19 January 2021

re: **MP07_0179-Mod- 6 - Cabarita Mixed Use Development - Lots 184 – 187 & 191-194 DP 259164 and Lots 20-23 DP 31208, Tweed Coast Road and Hastings Road, Cabarita Beach/Bogangar (Now known as Lot 1, DP 1185345, 39 Tweed Coast Road, Bogangar)**

I refer to correspondence from the Dept of Planning, Industry and Environment dated 18th December 2020 and advise as follows;

dwg no DA-10 rev no C

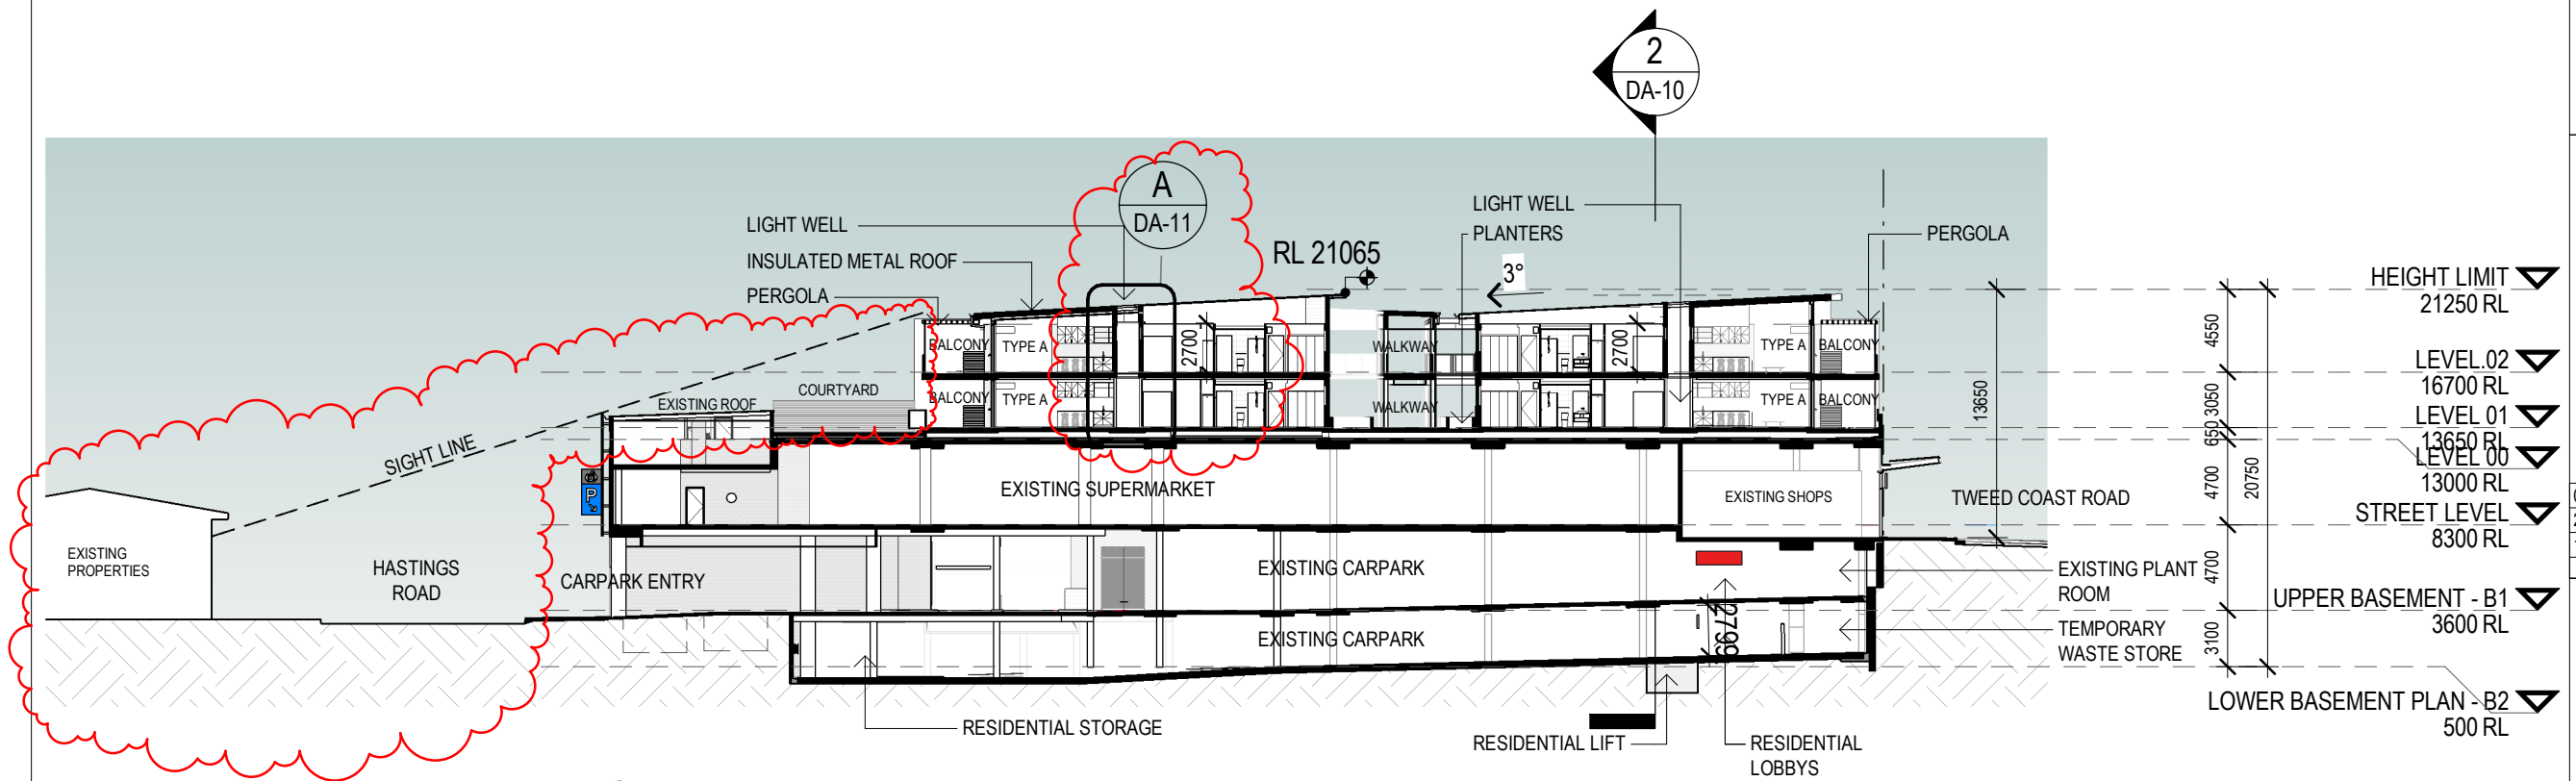
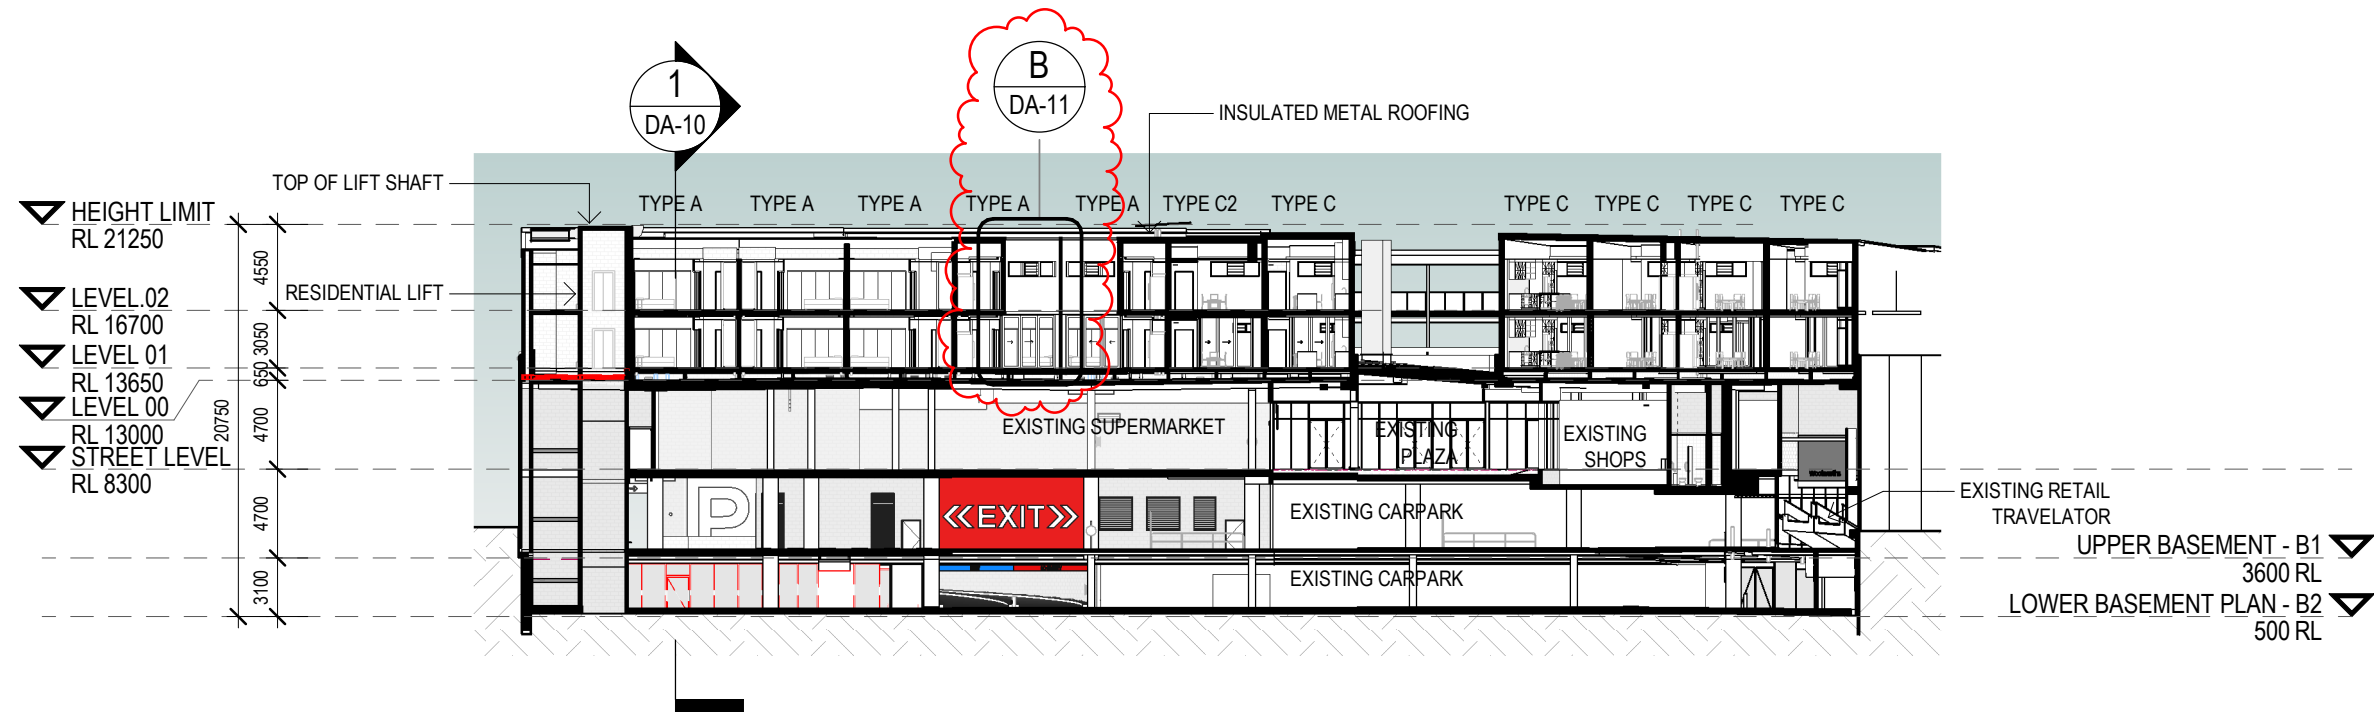
- **Level 1 Podium Plan**

In response to concerns regarding the adaptation of the inaccessible landscape podium to courtyards for respective Units 1-8, additional plans have been provided. Updated drawing DA.10 [C] is attached detailing sightlines from the neighbouring properties in Hastings Street. This section demonstrates that neither the courtyards nor the units are visible from properties opposite.

project no P1710	scale 1 : 50	@A3
dwg no DA-11	rev no A

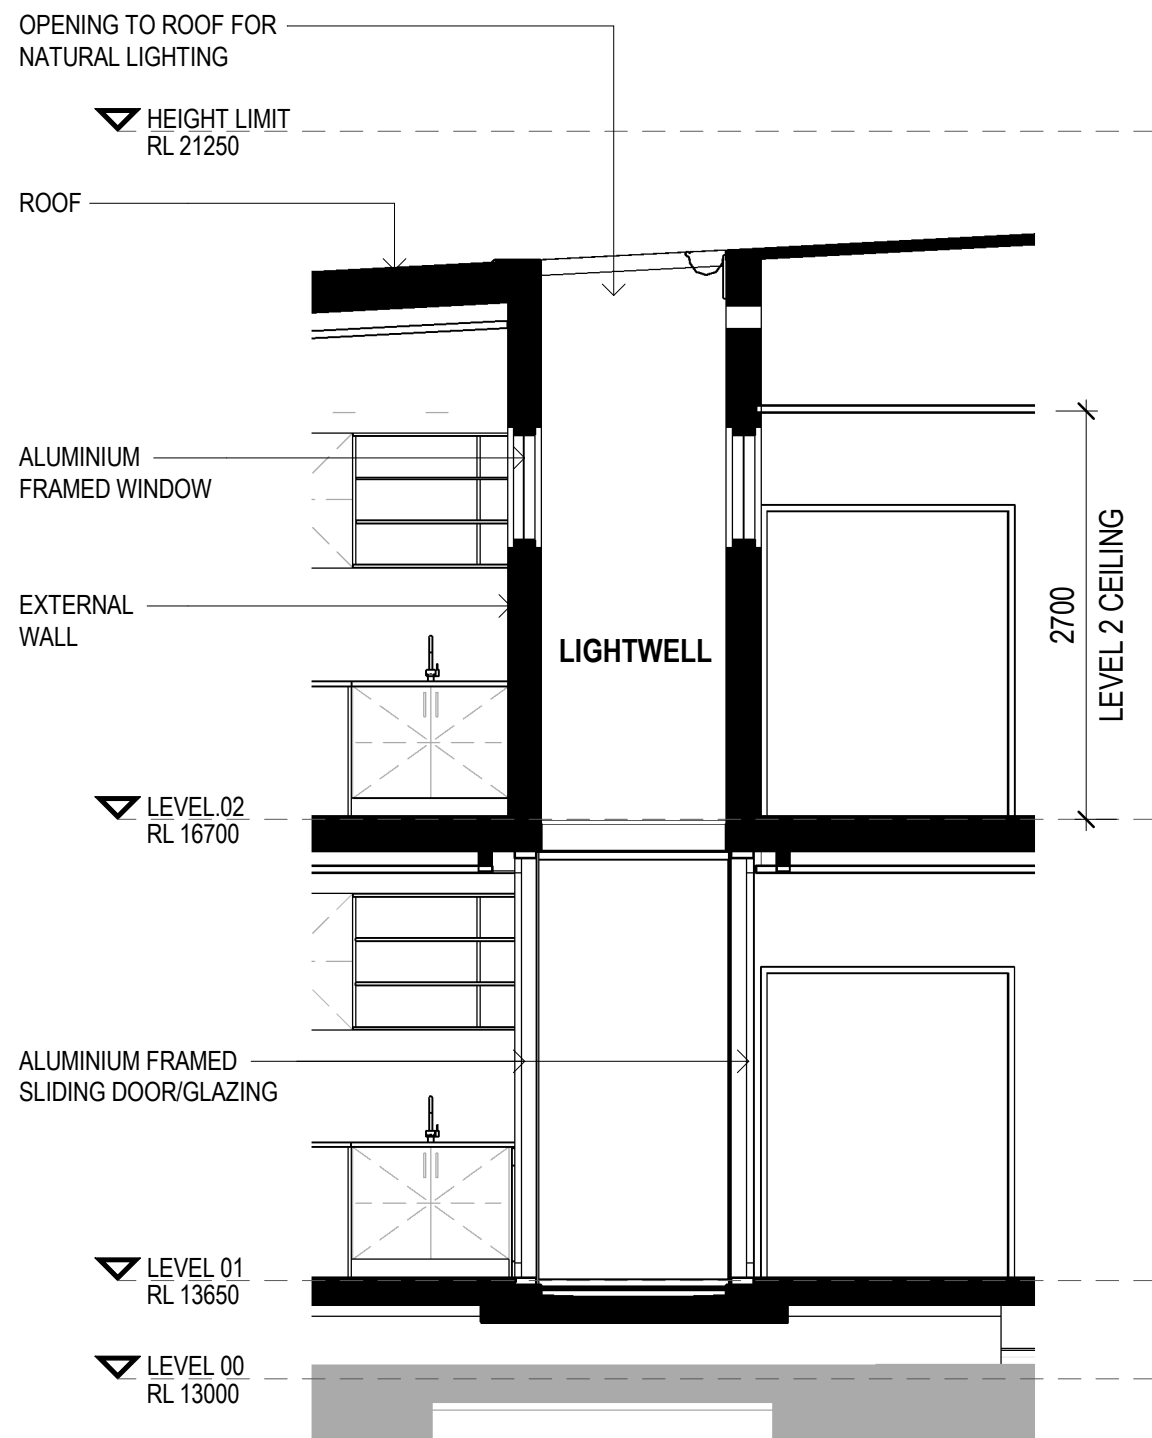
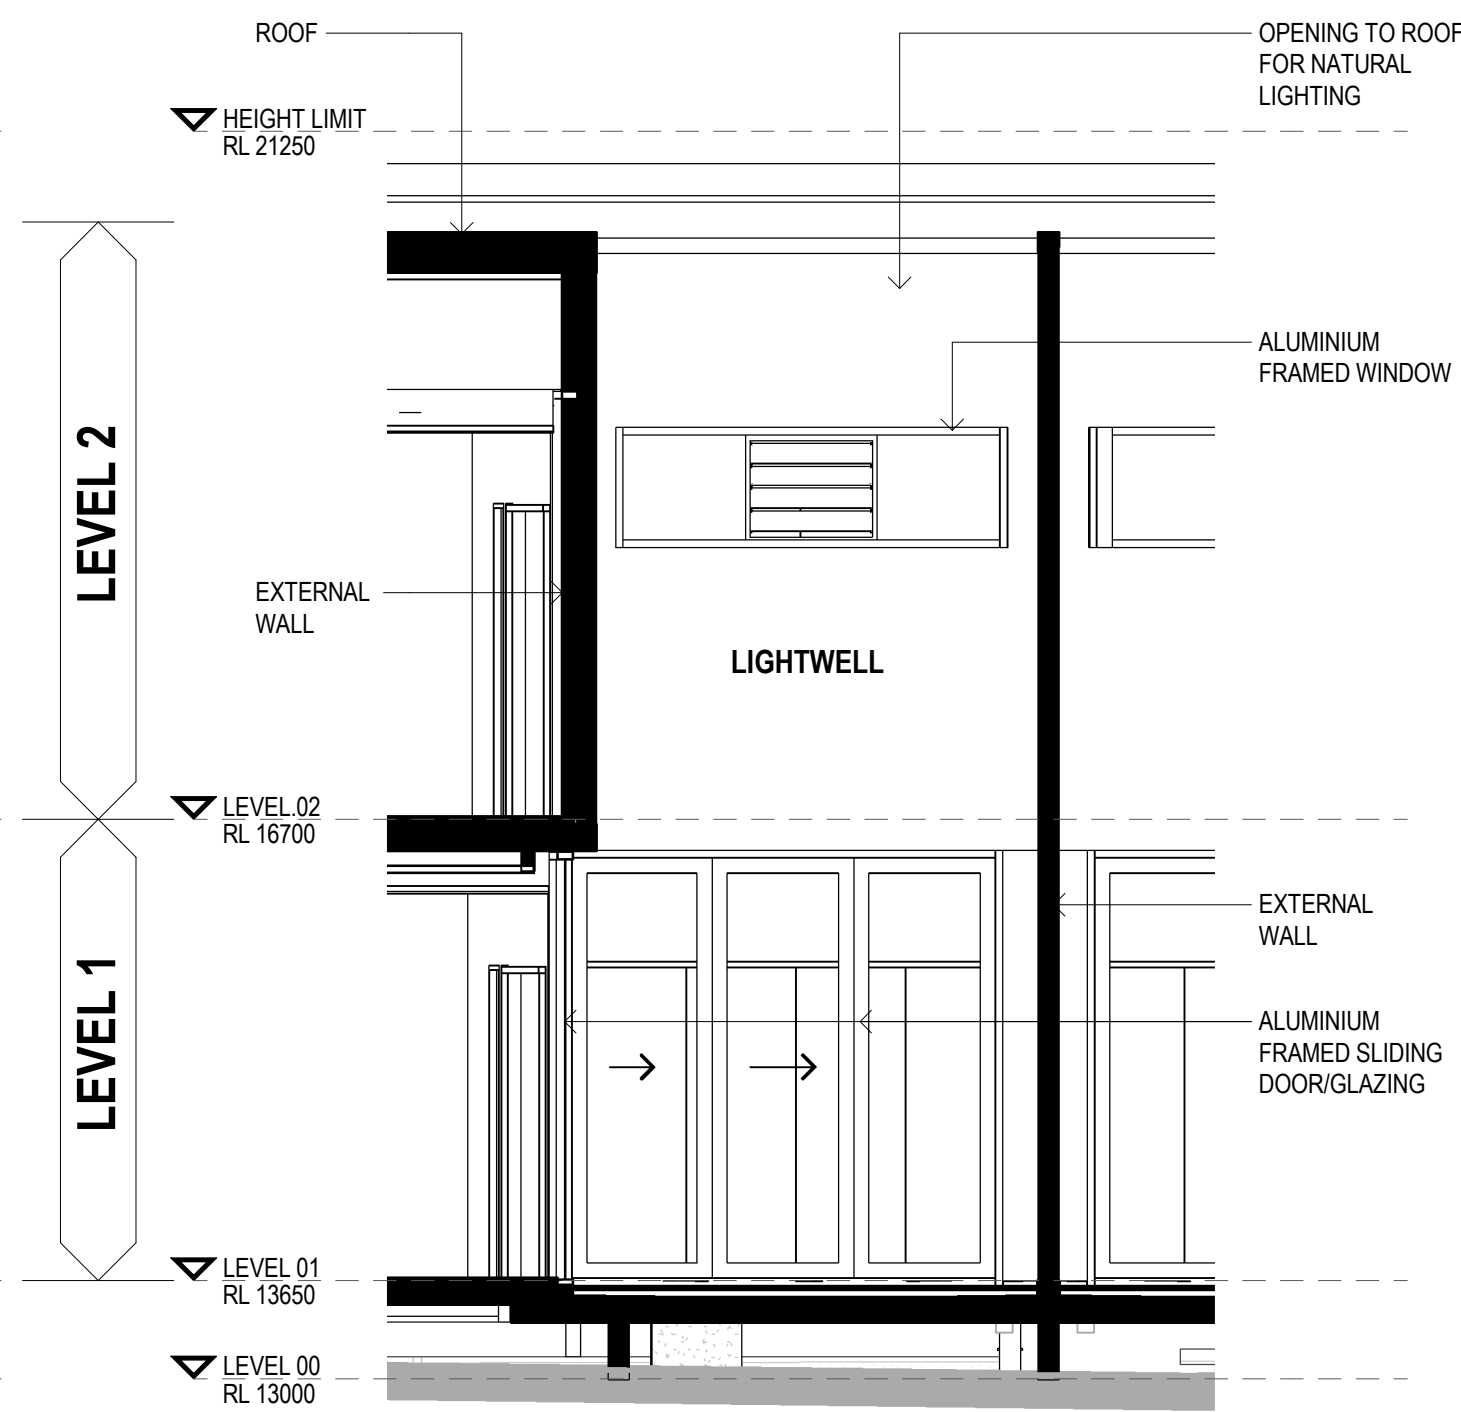
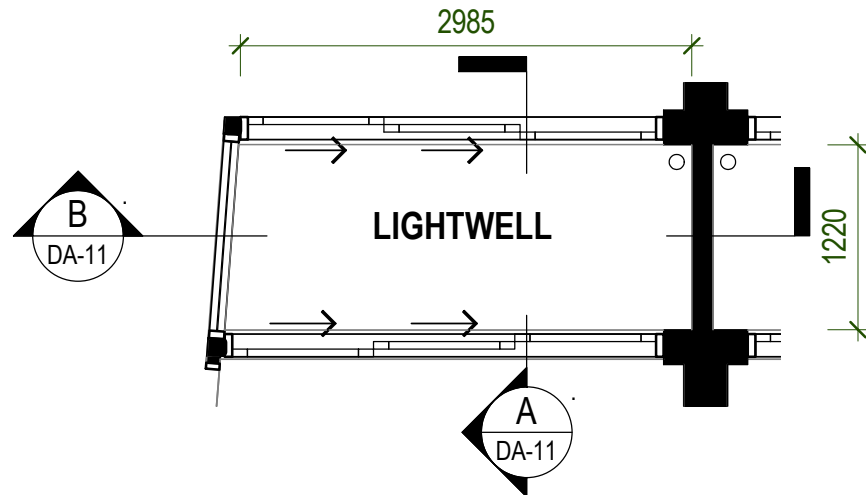
- **Lightwells**

New drawing DA.11 [A] attached provides 2 x sections through a typical lightwell that show how the lightwells provide natural light to both the level 1 and level 2 units.

Units at level 2 have high level windows at the lightwell in both the bathroom and kitchen/dining area where the sills are 1800mm above floor level. These windows are a combination of fixed glass and louvres to provide natural light and ventilation. There is no access into the light wells from level 2 units. The high level sills ensure privacy to the level 1 units below.

Units at level 1 have a high level window at the lightwell to the bathroom where the sill is 1800mm above the floor. This window is a combination of obscure fixed glass and louvres providing both natural light and ventilation while ensuring privacy. The kitchen/dining area will have a full height window/sliding door providing access to the lightwell which also provides natural light and ventilation to the unit.
